Subject: FW: Hazeldene House - 2021/93565

From: William Simcock <William.Simcock@kirklees.gov.uk>
Sent: 25 November 2021 11:27
To: Hamish Gledhill <hamish@acumenarchitects.co.uk>
Subject: Hazeldene House - 2021/93565

Description: **PROPOSED CONSTRUCTION MANAGEMENT PLAN**

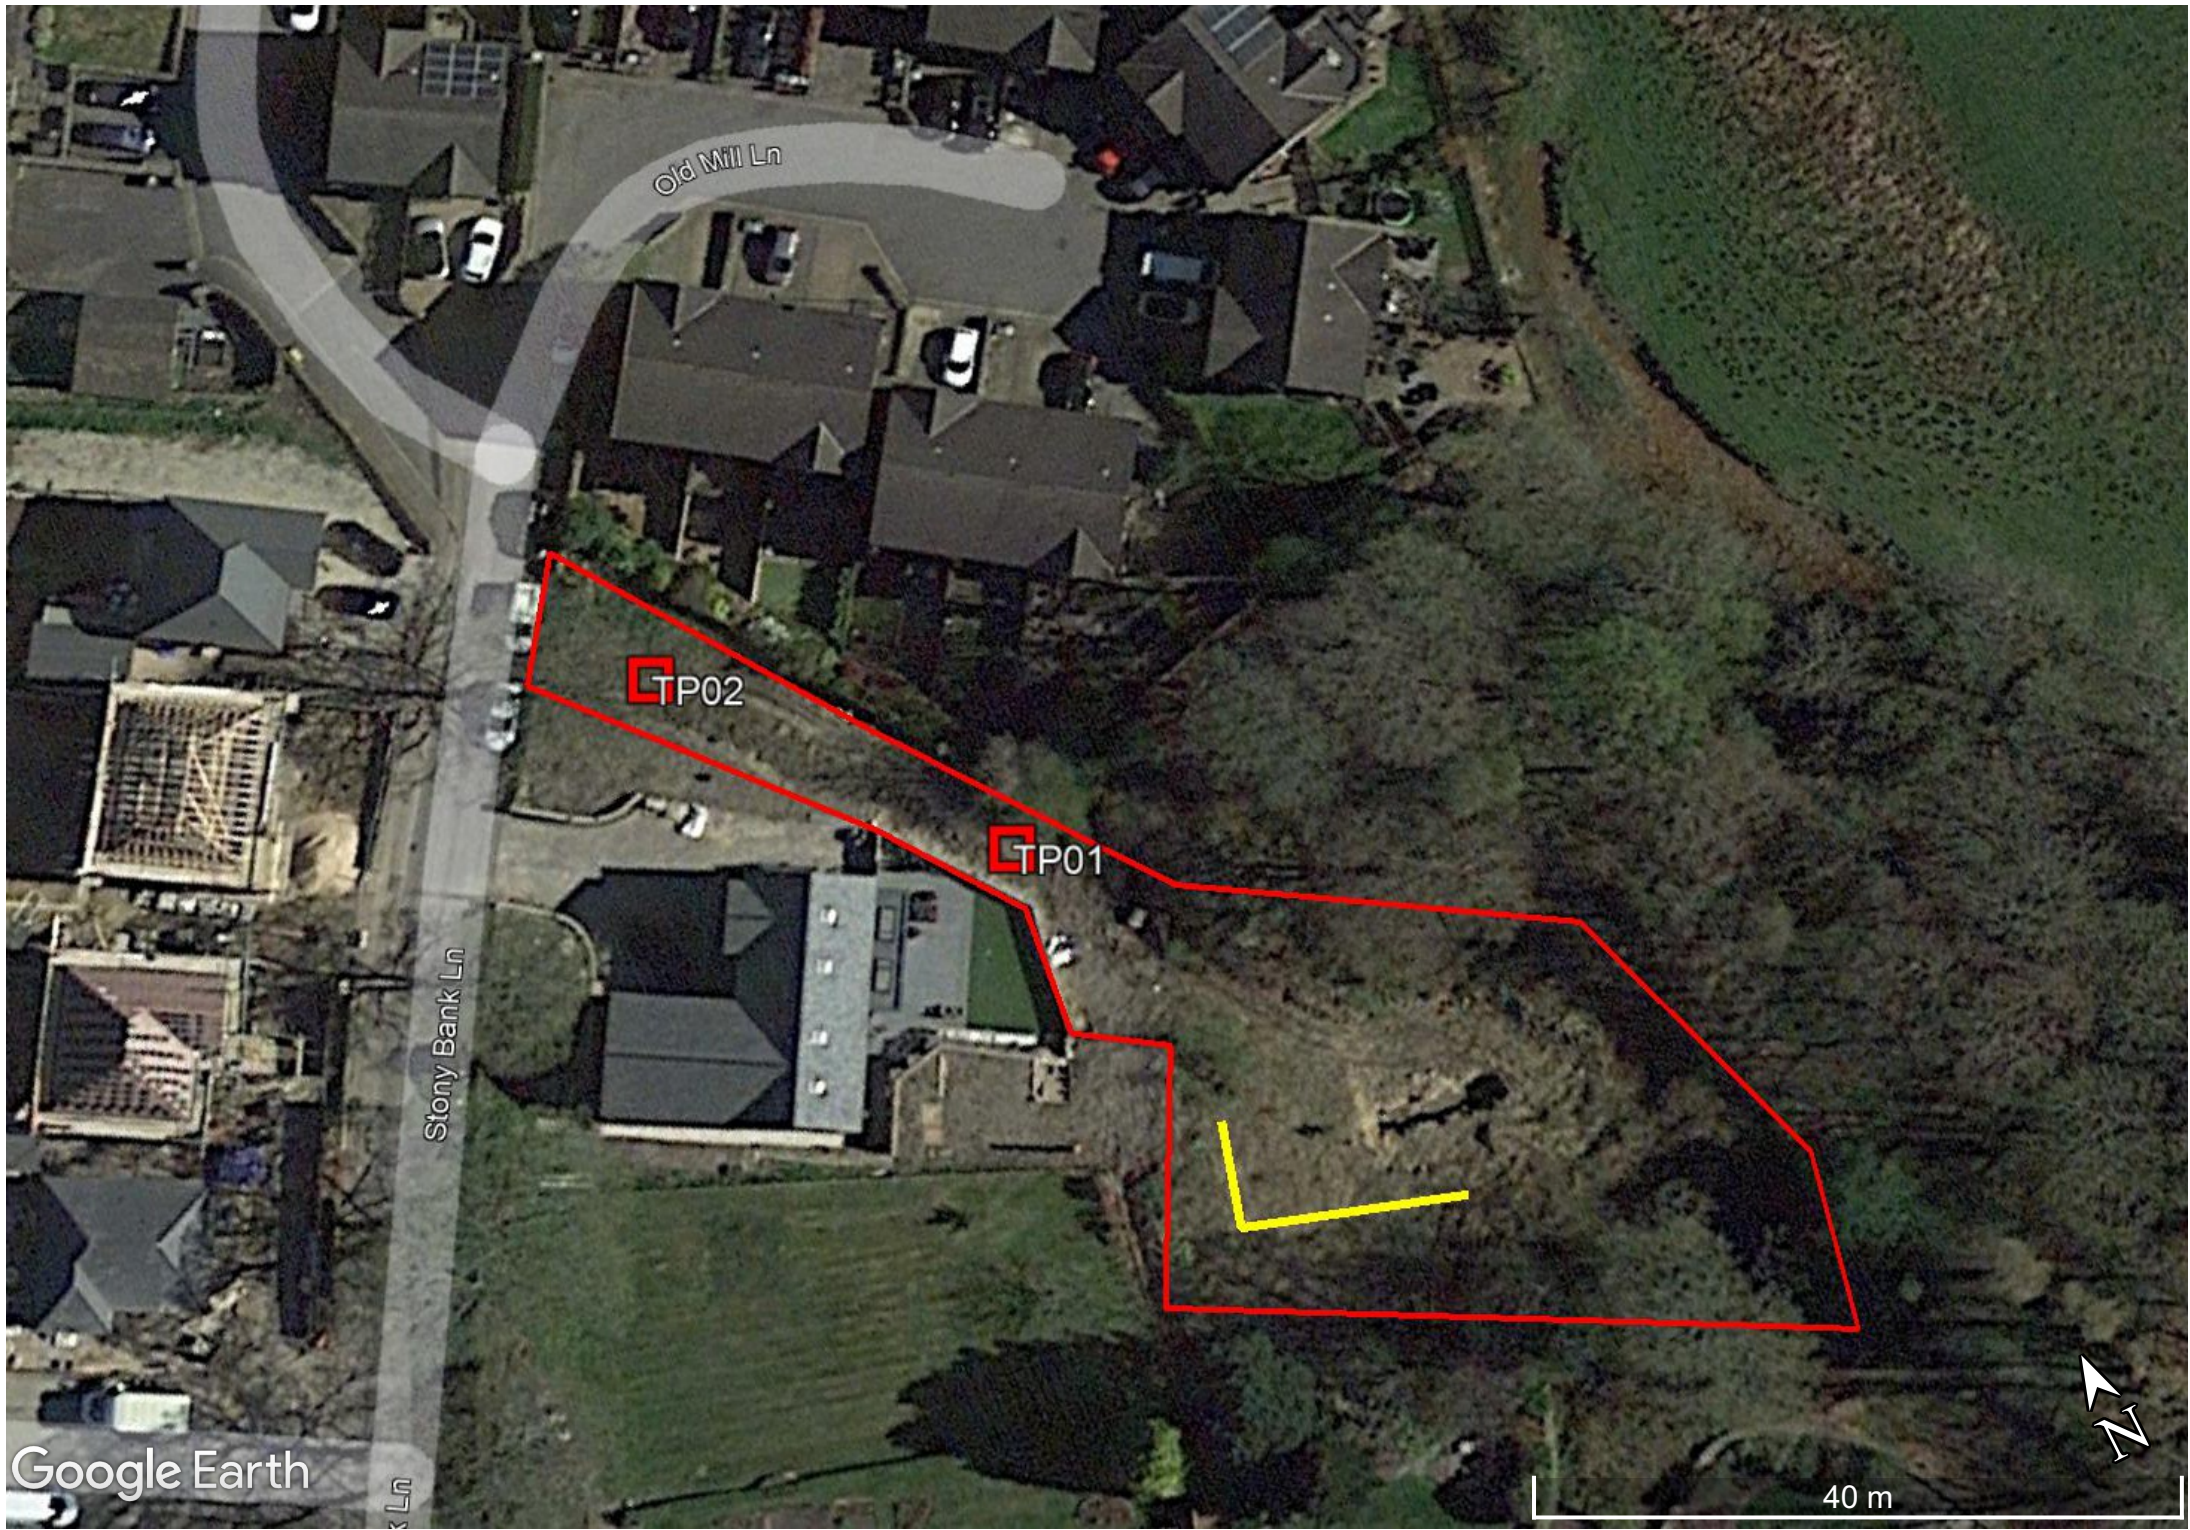
With reference to the above application, the Construction Management Plan (9.0) states that “there will be no operation of heavy plant, etc, outside normal working hours of 0800 to 1800”

Will this apply only on weekdays?

Environmental Health's standard recommendation is that noisy activities should not take place outside the hours of 07.30 to 18.30 hours Mondays to Fridays, 08.00 to 13.00 hours, Saturdays, with no noisy activities on Sundays or Public Holidays.

I have checked this, please can we agree the standard hours that include Saturday mornings?
